Our Case Number: ACP-322958-25

Re: Athlone link road phase 2. Proposed link road, joining the Crescent Junction (R915) to Southern Station Road Junction
Athlone, County Westmeath

Subject: Objection to Proposed Road Construction [An Coimisiún Pleanála – Case
Reference Number: JP25M.322958]

Drawing file: Drawings / 120278-5001 PL1 Vegetation to be Removed.pdf

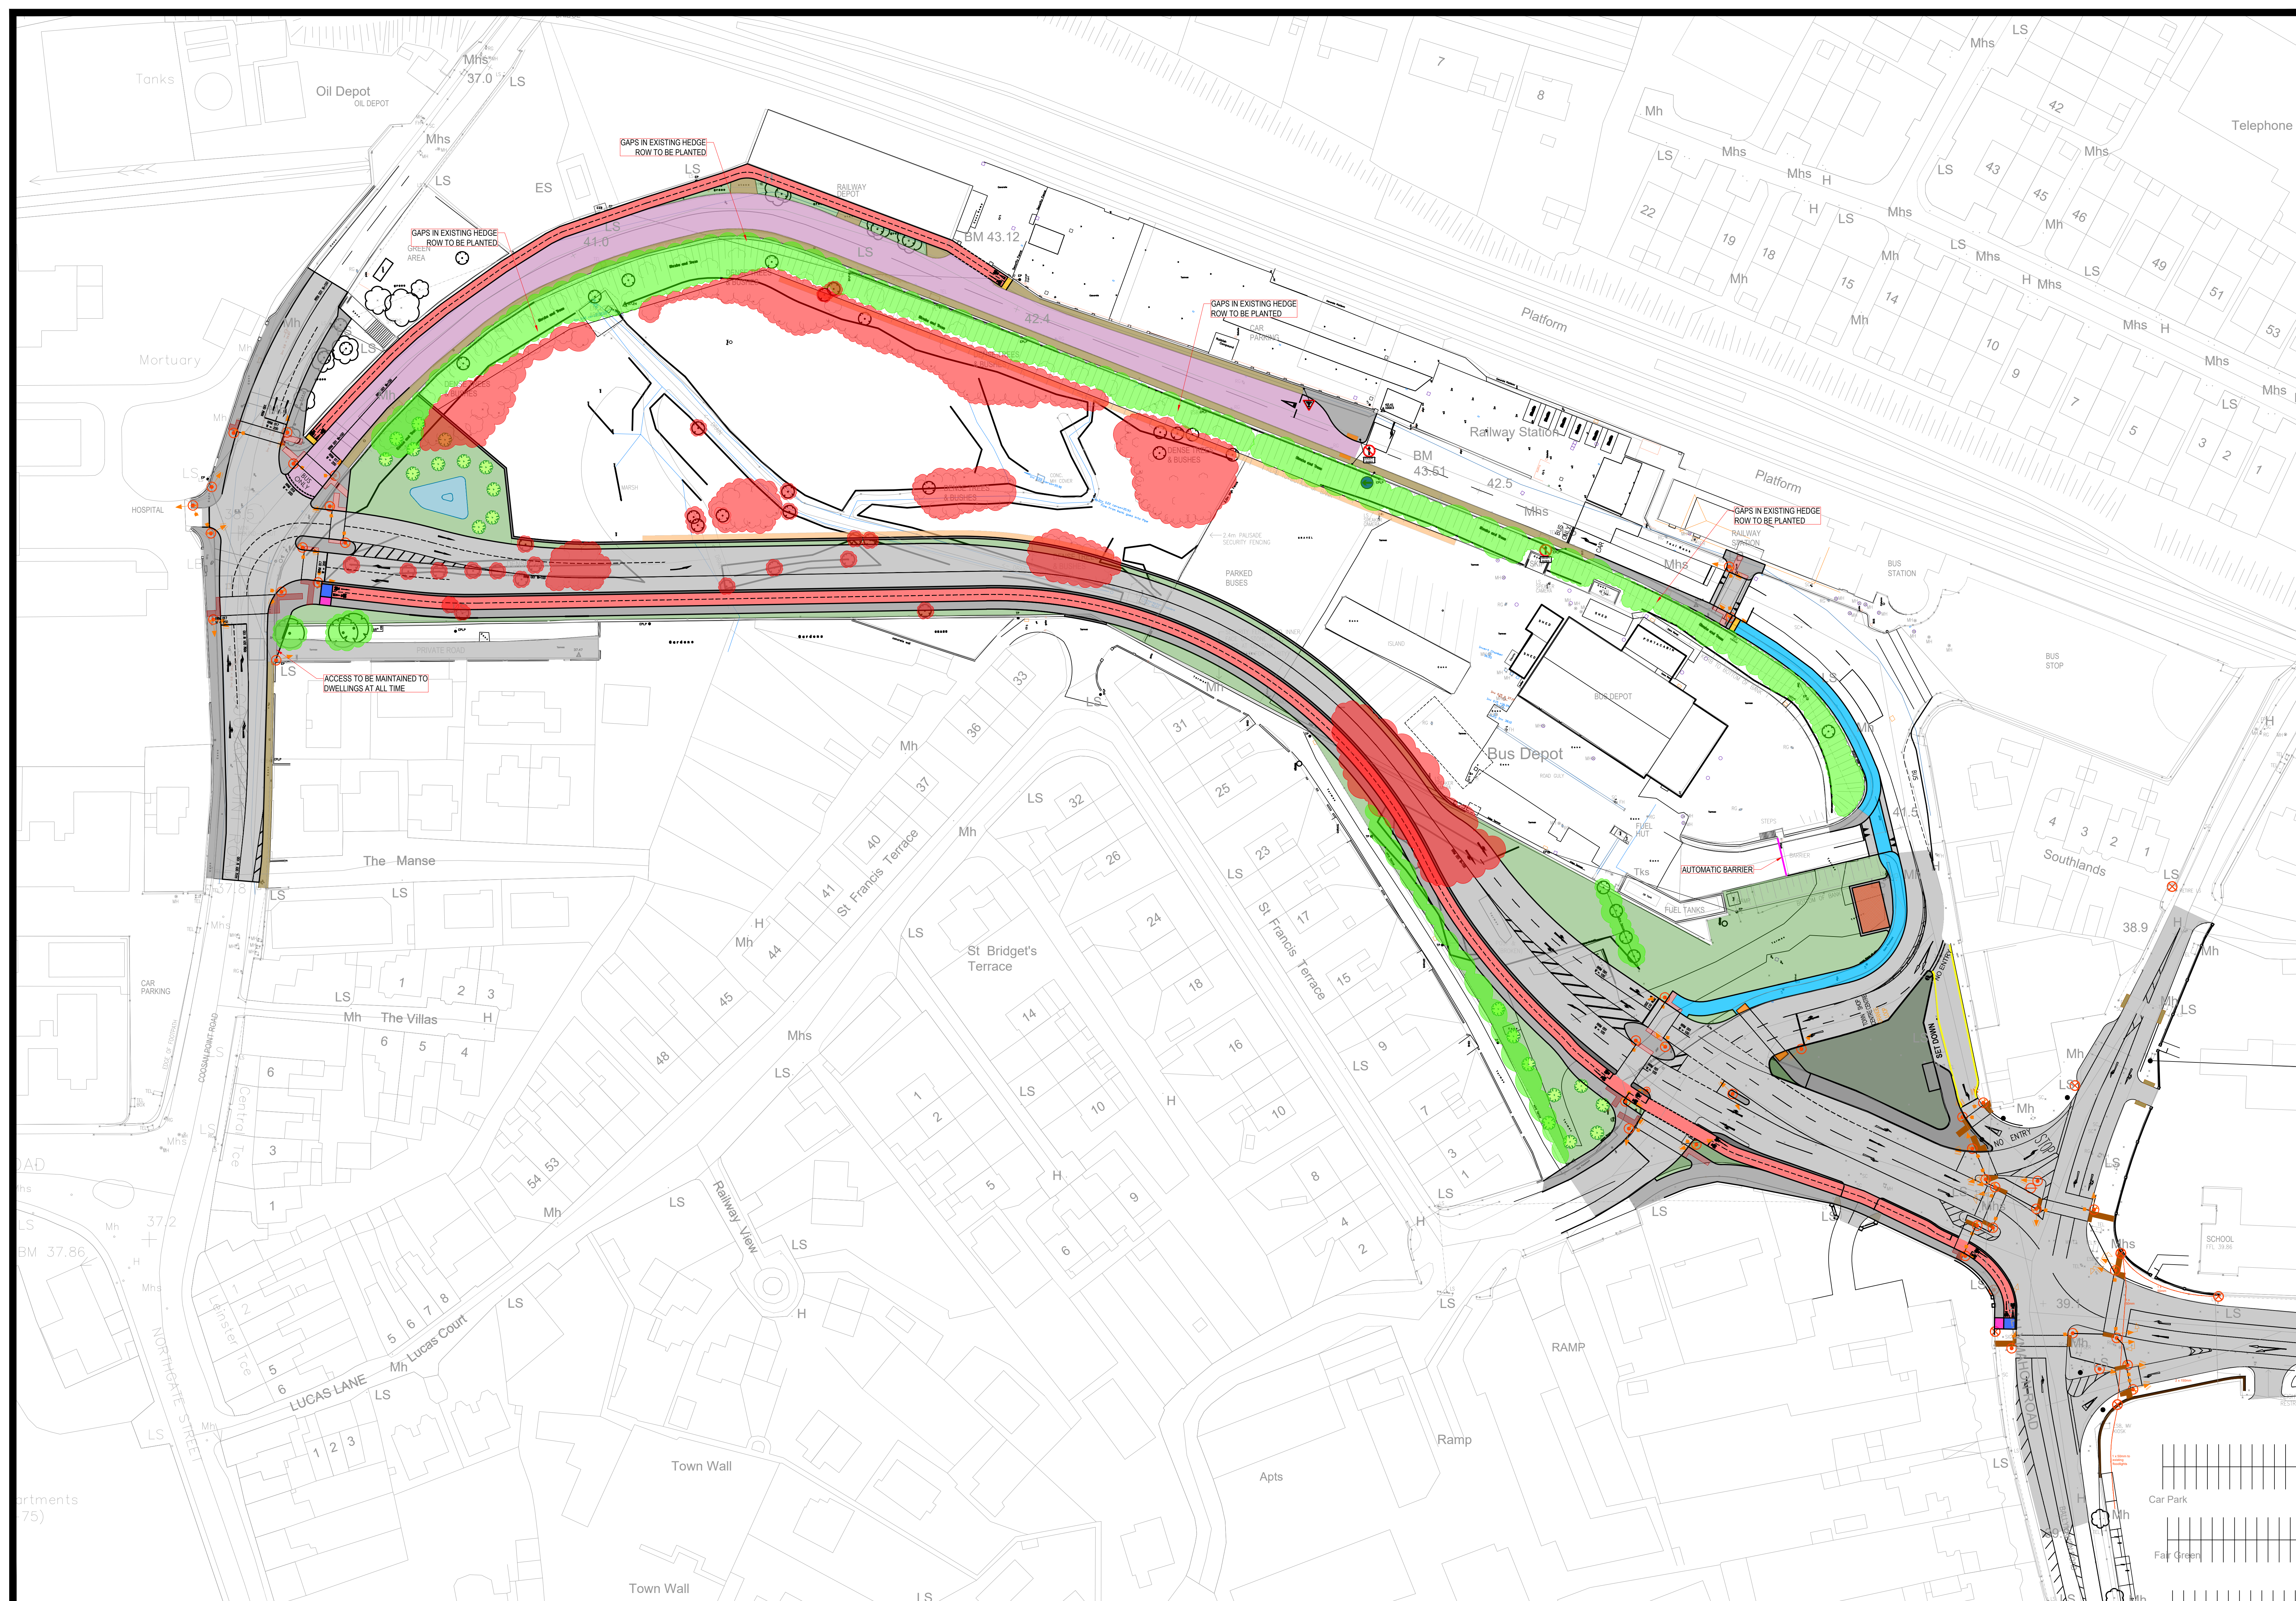
I must also draw attention to the document titles "*120278-5001 PL1 Vegetation to be Removed*". This document omits a significant number of trees and bushes that are clearly within the path of the proposed road and the planned bus depot expansion. Many of these trees are **native Irish hardwood species**, which are of particular ecological value and whose removal conflicts with Ireland's **National Biodiversity Action Plan 2023-2030** commitments. These omissions mean the document is inaccurate and fails to fully reflect the true environmental impact of the project.

Furthermore, I have been informed that the trees on my property, which borders the proposed roadway, will also need to be removed to facilitate the construction of the boundary wall. These trees, which also include native Irish hardwoods, are absent from the "*120278-5001 PL1 Vegetation to be Removed*" document, further highlighting its inaccuracy and the underestimation of environmental loss.
